From: [REDACTED]
Sent: 09 May 2023 18:32
To: Planning
Subject: FAO: Emily Pickup - Planning Application No: 3/2023/2035

planning@ribblevalley.gov.uk
Planning Application No: 3/2023/2035
Grid Ref: 373317 436329
Site Address / Location: 95 King Street, Whalley, Lancashire, BB7 9SW

Proposed Floor Plans and Elevations

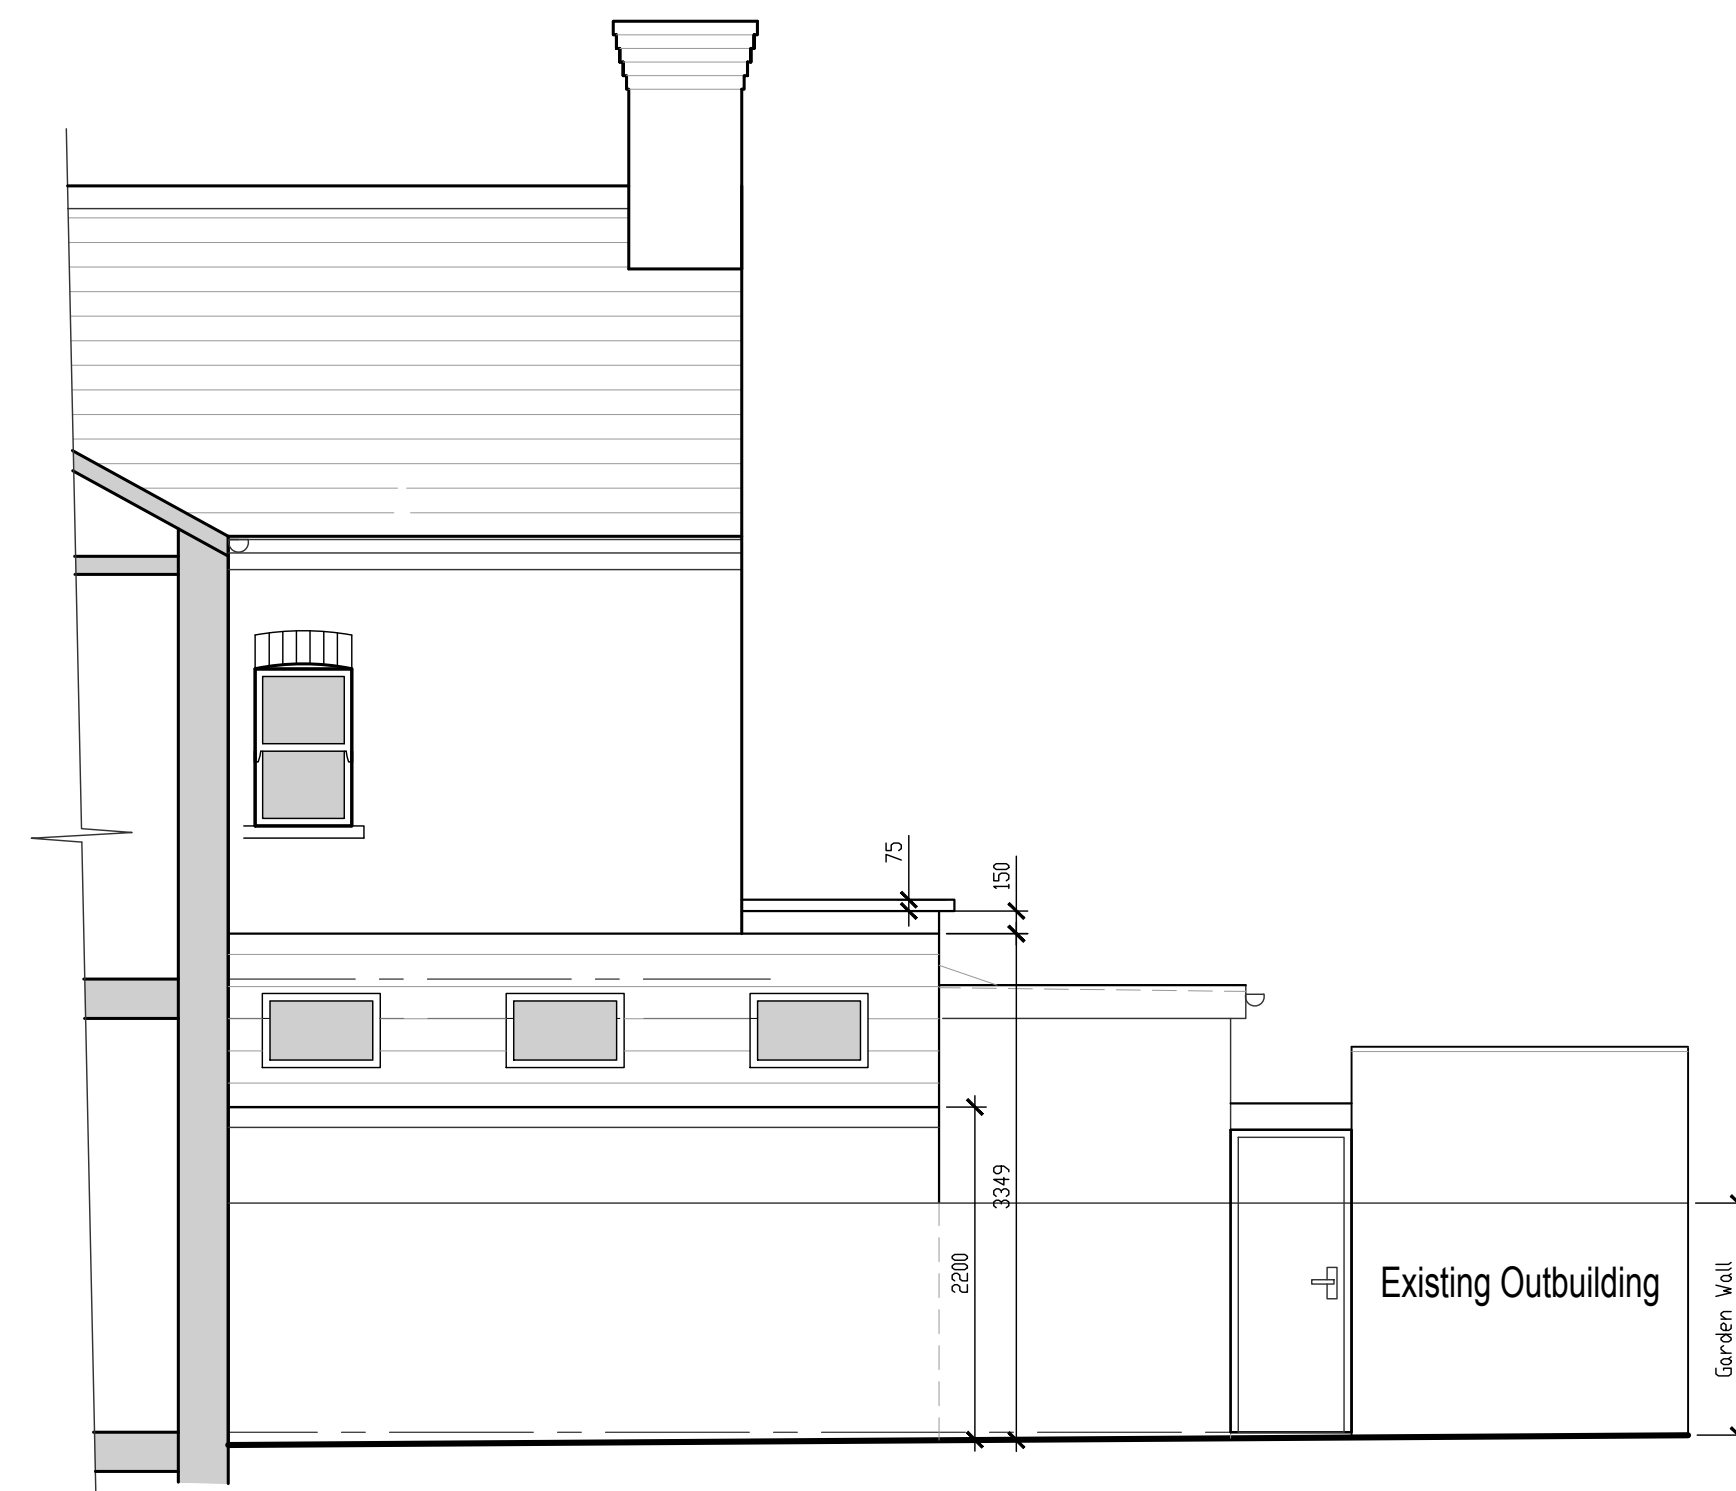
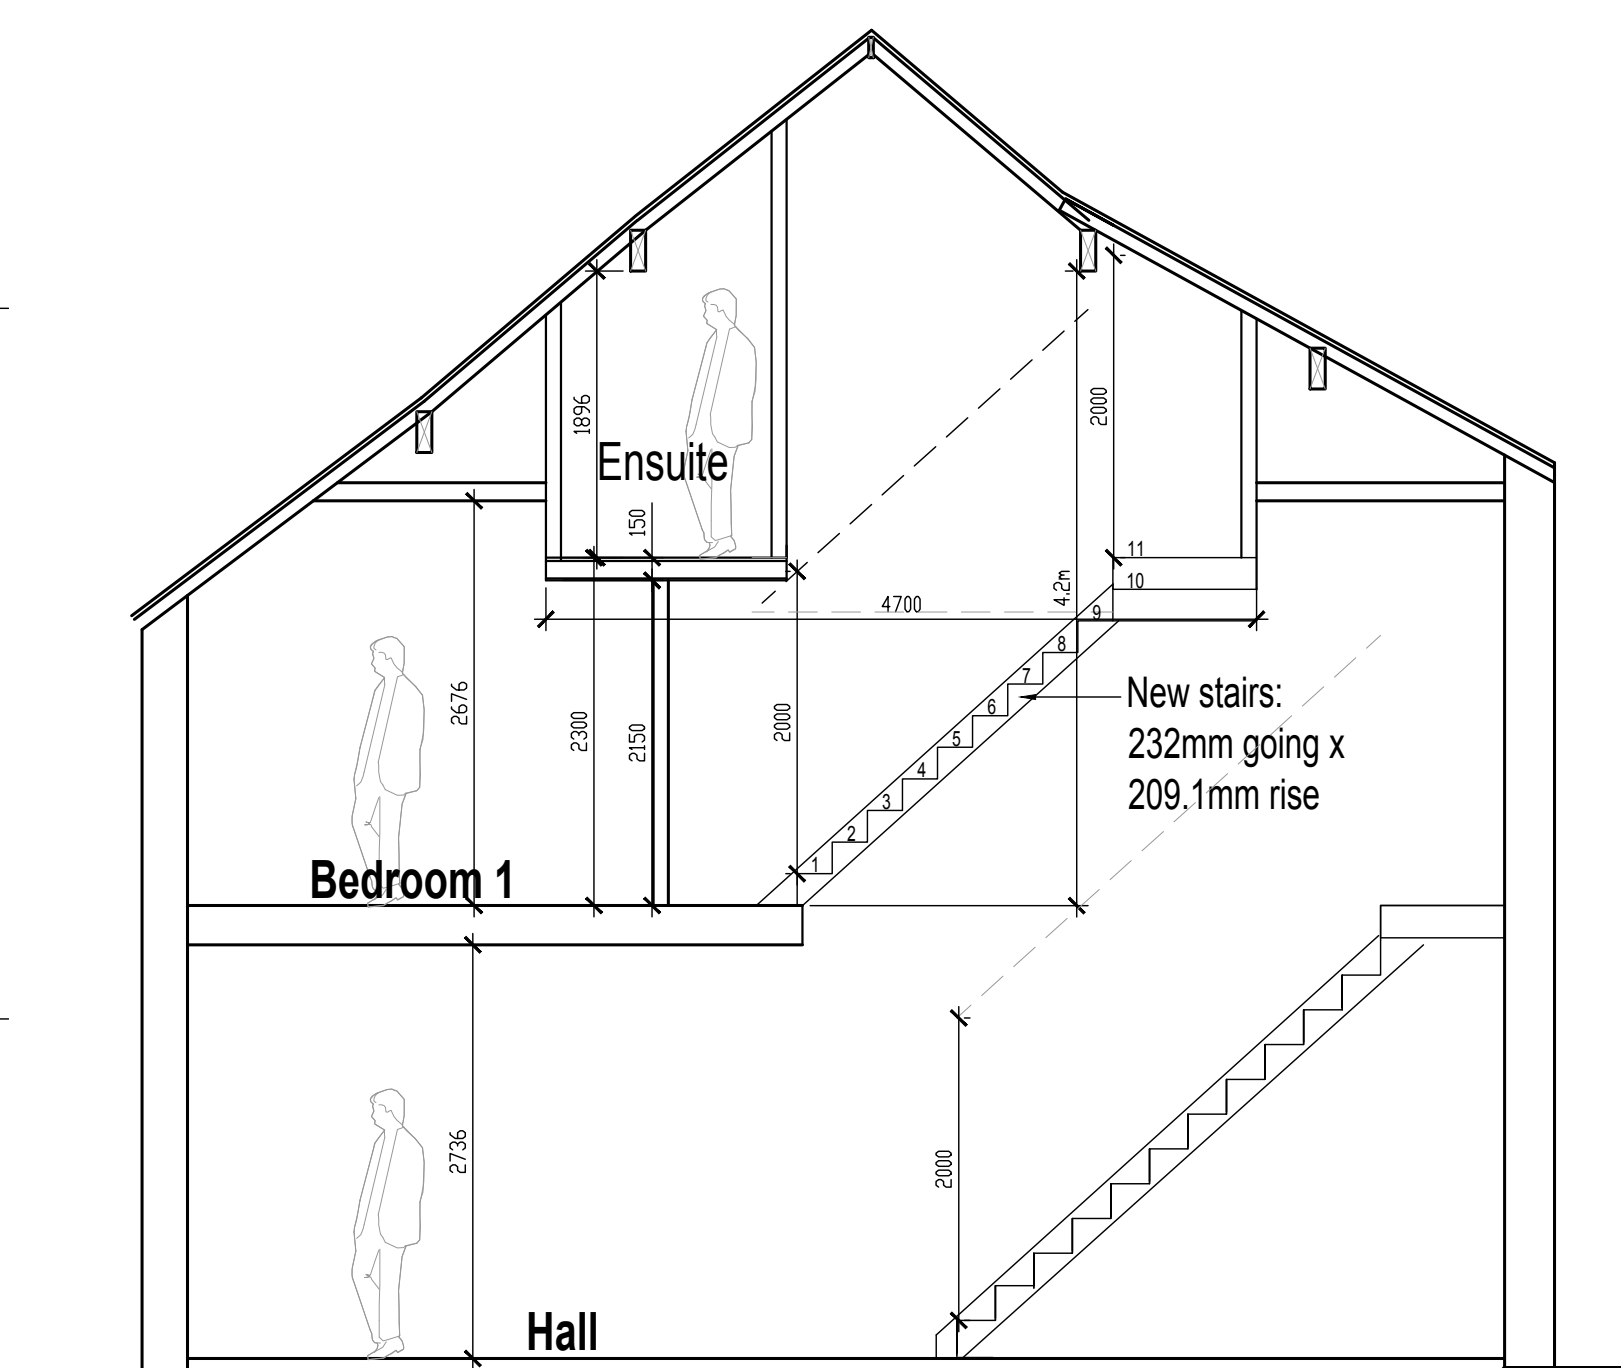
2. I am growing increasingly concerned about the height of the new roof and the dark materials that are going to be used on the kitchen extension in comparison to the current clear roof.

3. Please can you confirm the number of windows (roof lights) on the kitchen extension? Is this 2 or 3?

4. I am also concerned about the placement of the new guttering and overflow measures for the kitchen extension. The height of this suggests the guttering will be eye level. Is this correct?
